Reference	3/2021/0556
Alternative Reference	
Location	74 Higher Road Longridge PR3 3SY and land to the rear
Proposal	Application for reserved matters consent (appearance, scale, landscaping and layout) pursuant to outline planning consent (ref 3/2016/1082) for the demolition of 74 Higher Road and construction of up to 123 houses on land to the rear
Map Ref	361005 / 437575
Footpaths Affected	Bw35 Ribble Valley Longridge (3-2-Bw35) Fp36 Ribble Valley Longridge (3-2-Fp36)
Contact	Adam Birkett Tel: 01200 425111 Email: planning@ribblevalley.gov.uk
Response Date	7/30/2021
Web	
Link	https://www.ribblevalley.gov.uk/site/scripts/planx_details.php?appNumber=3%2F2021%2F0556

Lancashire County Council – Public Rights of Way has identified BW 3-2-BW35 and 3-2-FP36 (**see attached overlay**) in the vicinity of the proposed development and have no objections to this application, however the following will need to be adhered in relation to Public Rights of Way.

Plot Landscape Detail
Planting Specification Sheet 1 of 3
Higher Road, Longridge

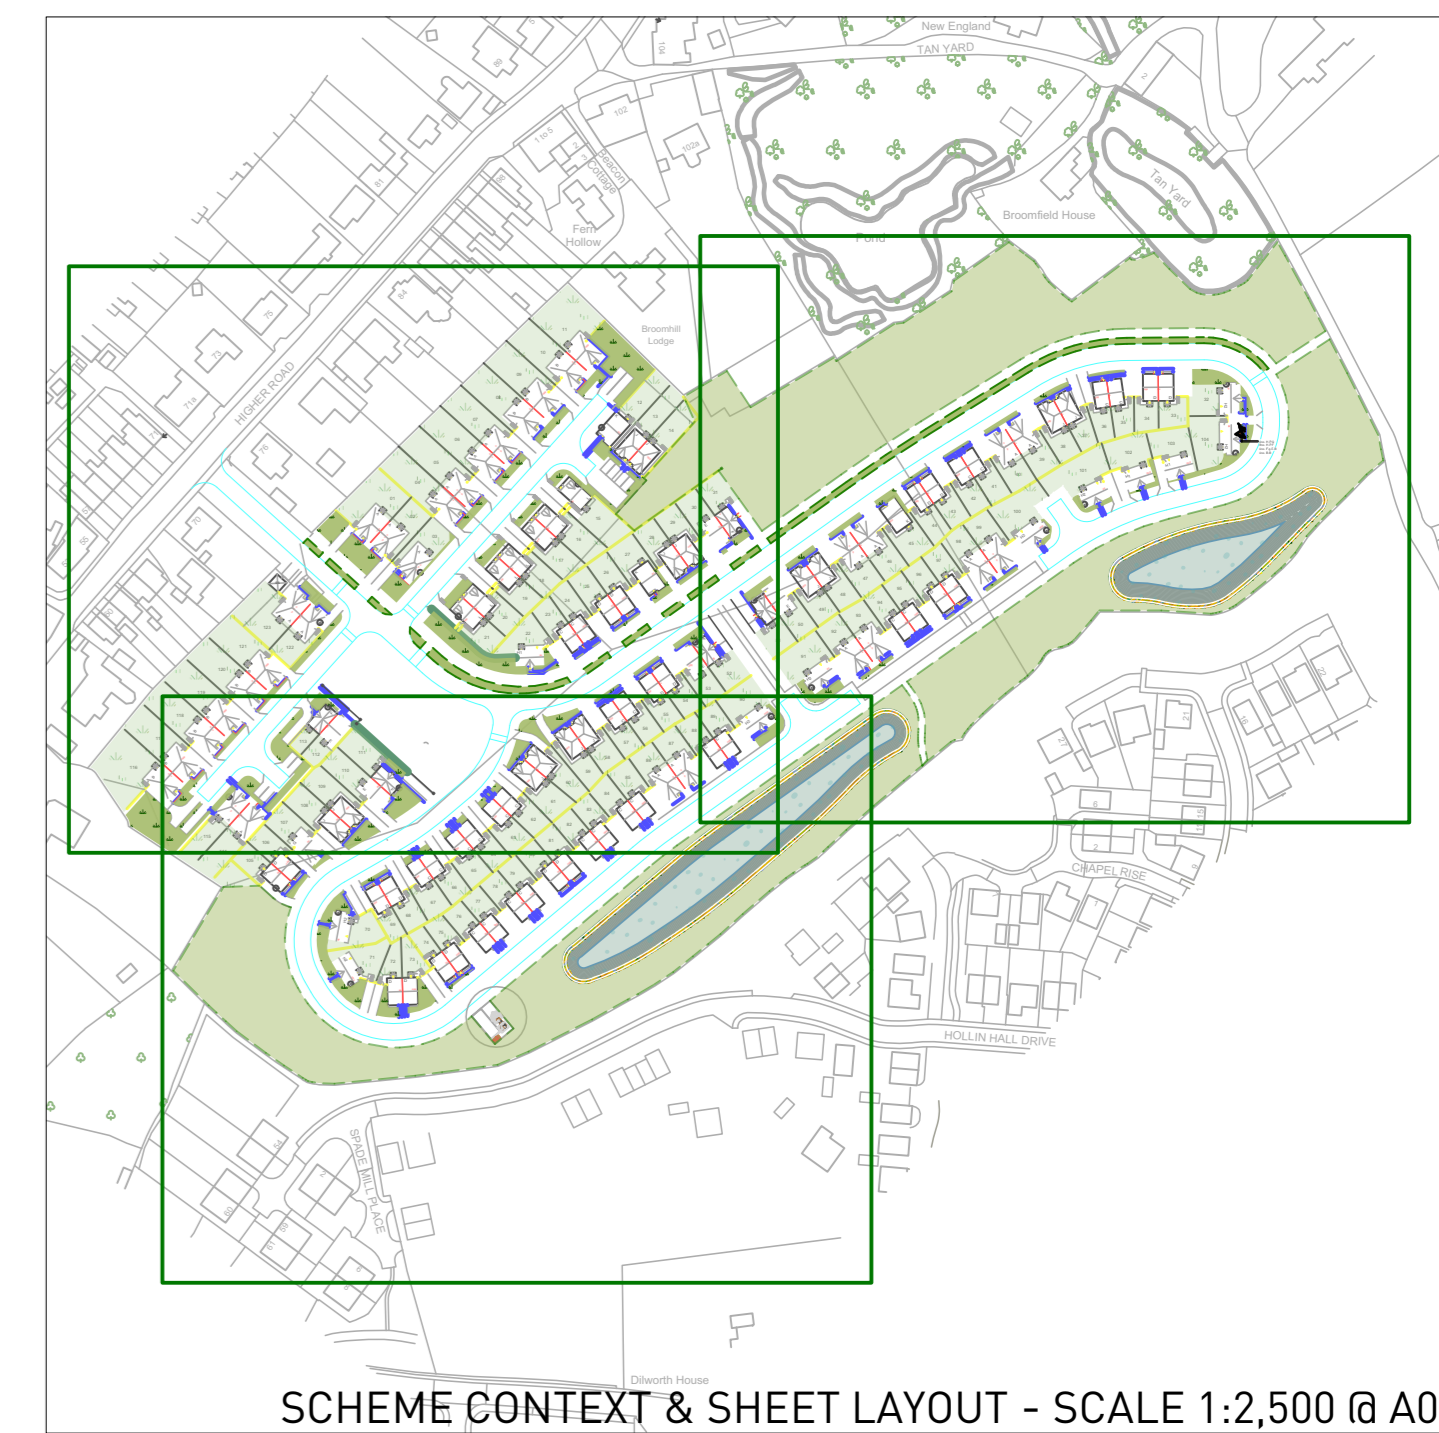
- Any landscaping should be at least 3 metres away from a Public right of way that is either within the proposed development site or in the vicinity – ***this is to prevent encroachment of roots onto or through a Right of Way surface, overhanging branches or foliage that could cause a health and safety risk to users of the Right of Way or cause an obstruction.***
